INDEPENDENT REVIEW

CROOKWELL 3 WIND FARM PROPOSAL

*Prepared for
NSW DEPARTMENT OF PLANNING
& ENVIRONMENT*

JULY 2018
REF: 918-Z-03
REVISION C

Figure 5 | Land Use Zoning - Upper Lachlan LEP 2010

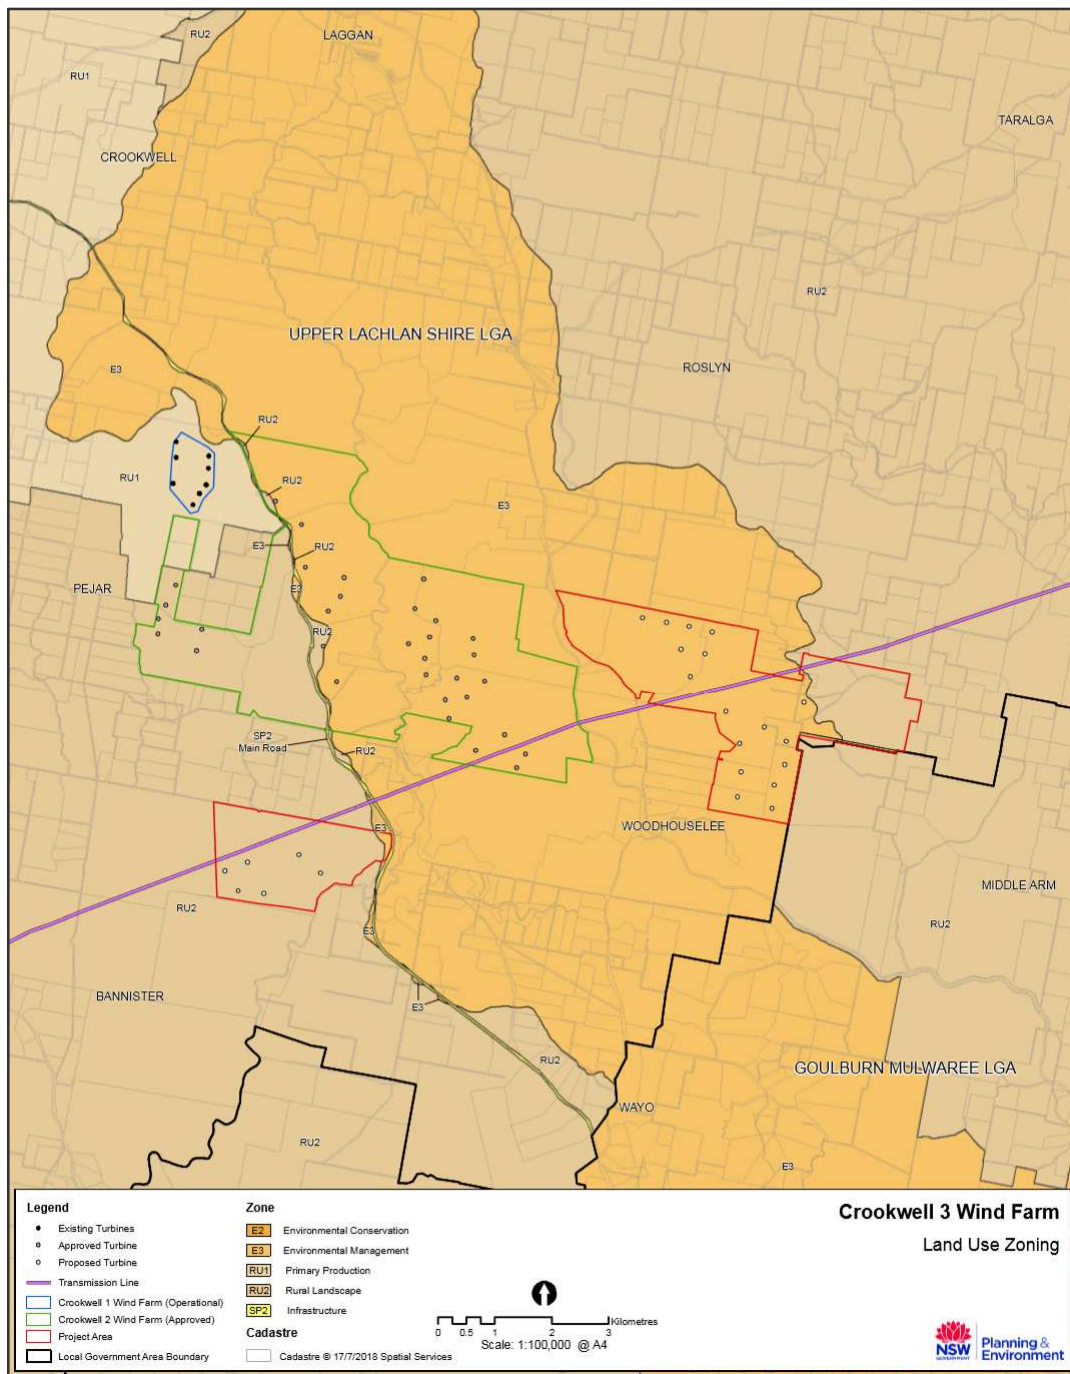
The proposed development of Crookwell 3 would place several turbines within the area zoned 'E3 Environmental Management'. It is our opinion that this would adversely affect the aesthetic value of the landscape area covered by the E3 zoning.

Figure 12 | Wireframe of view looking north-east from **Pejar Dam picnic area** (Distance to nearest turbine (A33): 1.2km)

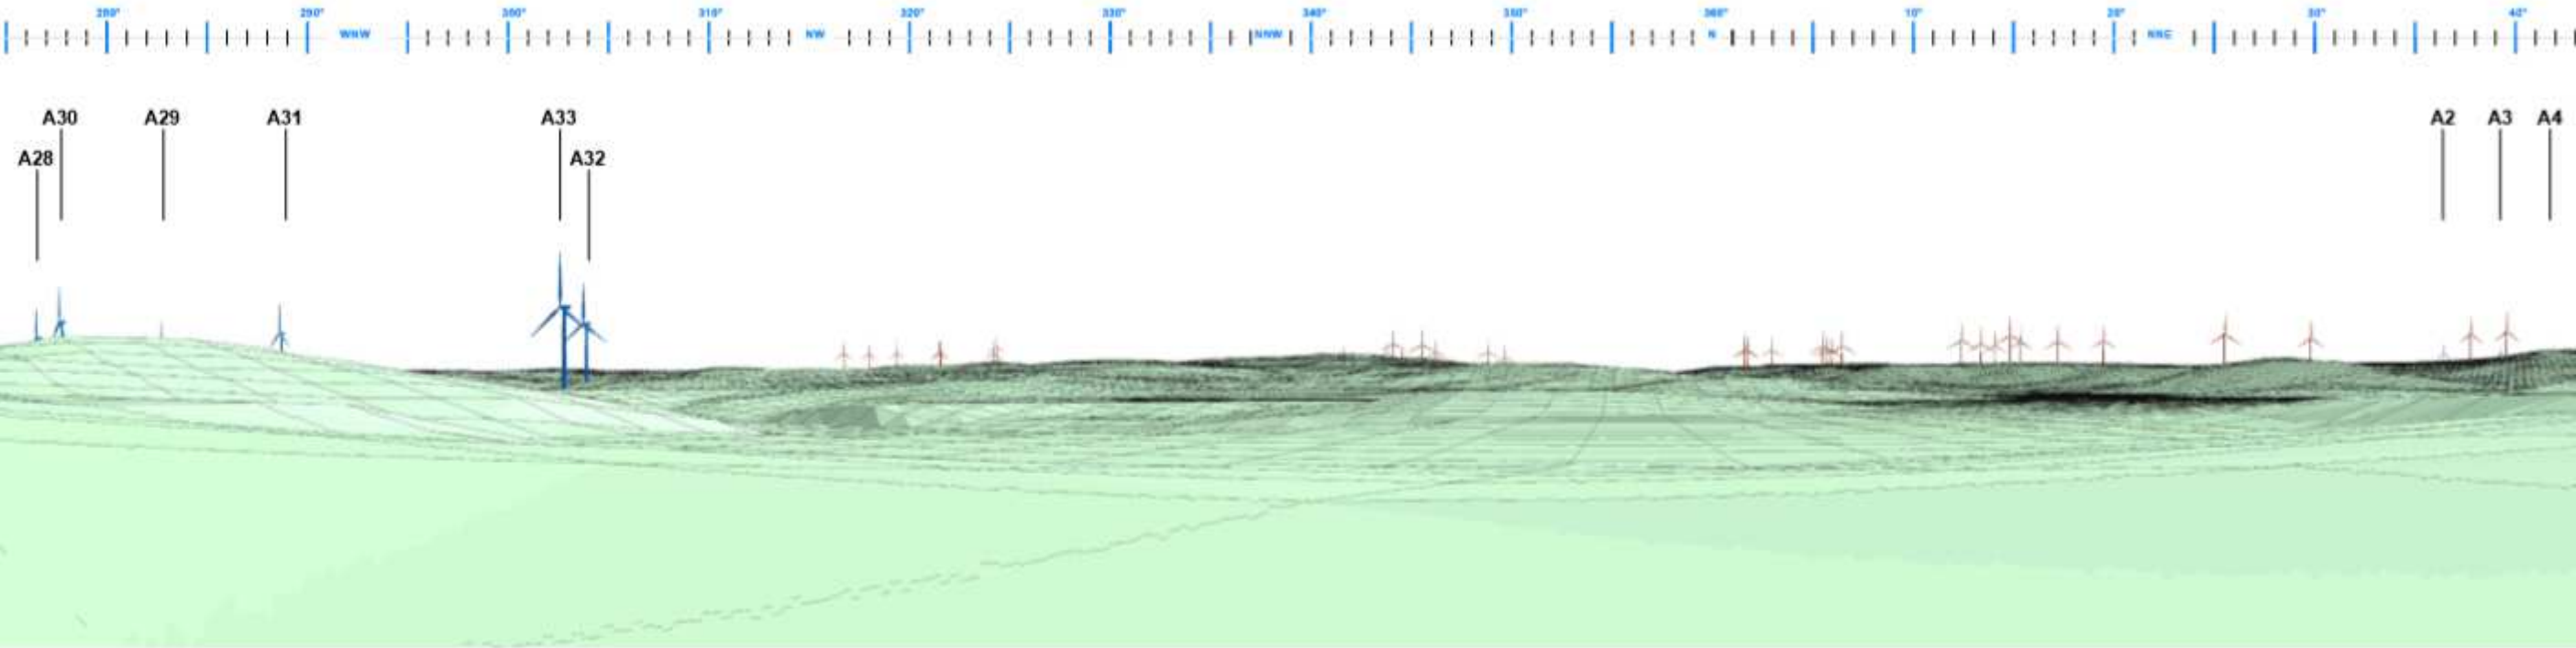
The proposed development of Crookwell 3 would have considerable impact on the visual amenity to and from Pejar Dam. The Pejar Dam area is a key landscape feature and impacts on this feature should be limited to maintain the existing landscape character. It is our opinion that the development of Crookwell 3 would significantly extend the impact on the visual amenity of the Pejar Dam area beyond that created by the existing/approved wind farms in the area.

Figure 16 | Wireframe of view looking south-east from residence **R69 Atholvale** (OHD Report rating: Mod-High. Distance to nearest turbine (A2): 1.3km)

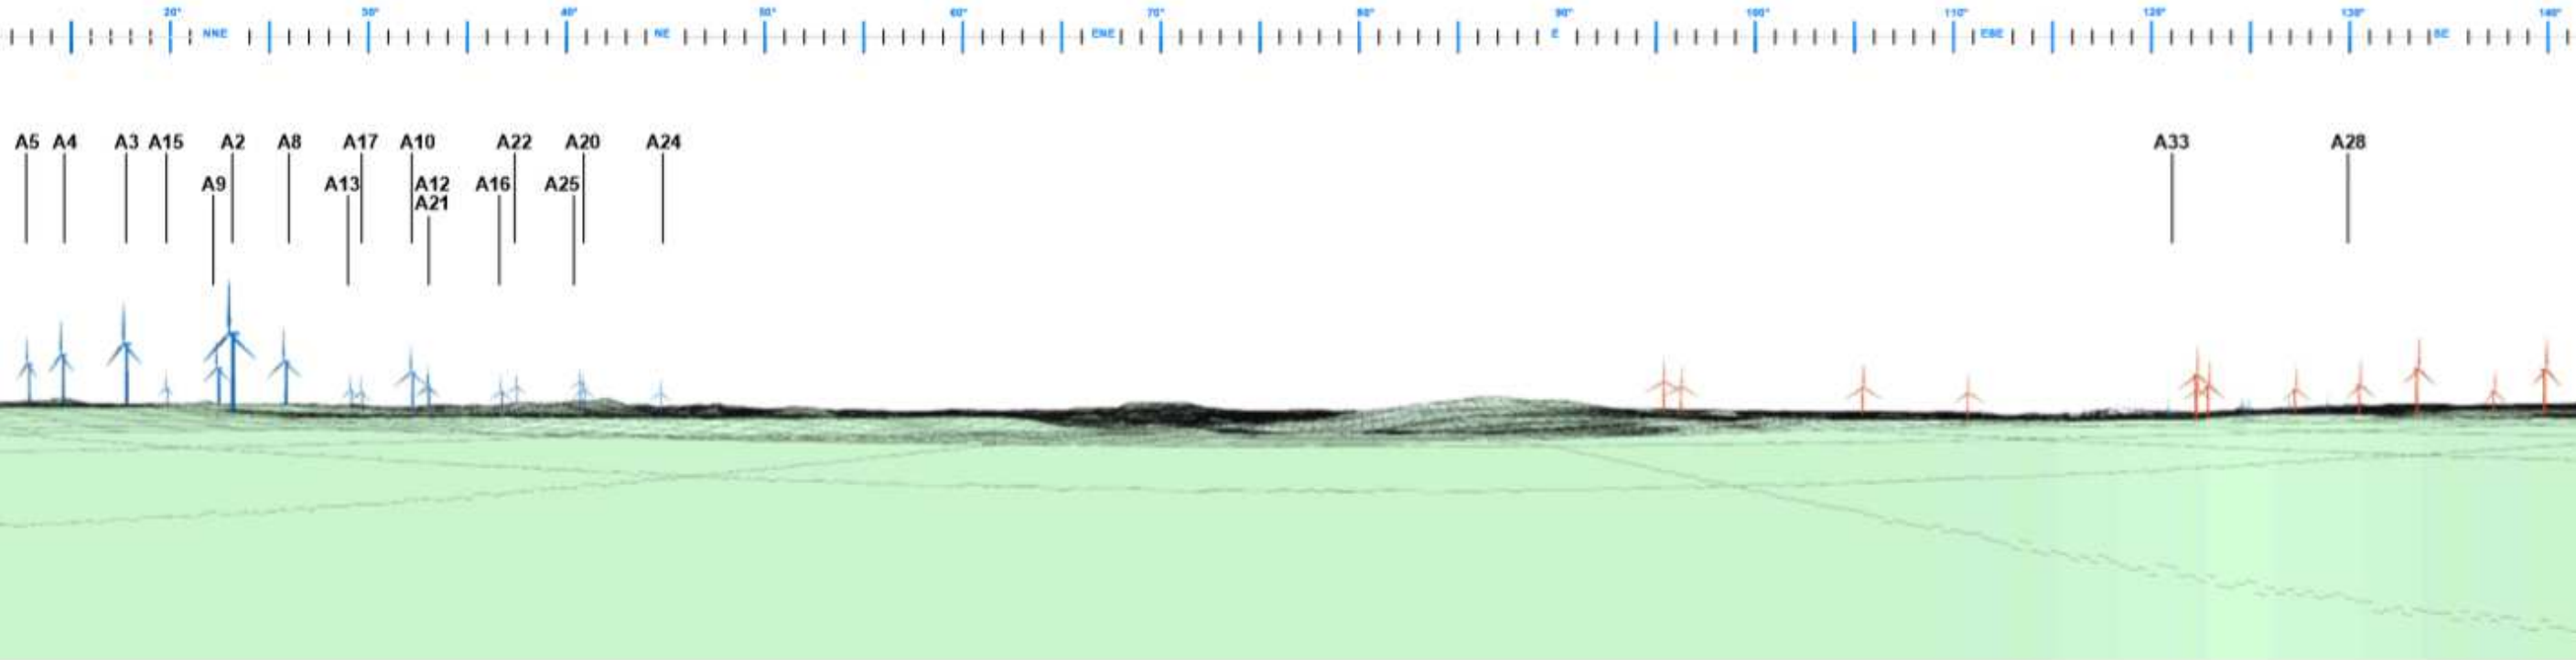
Moderate to High levels of dominance at residences 68, 69 with some screening, and with open views at 106 indicate that consideration should be given to removal or amelioration of turbines A2, A3, A4 and A5.
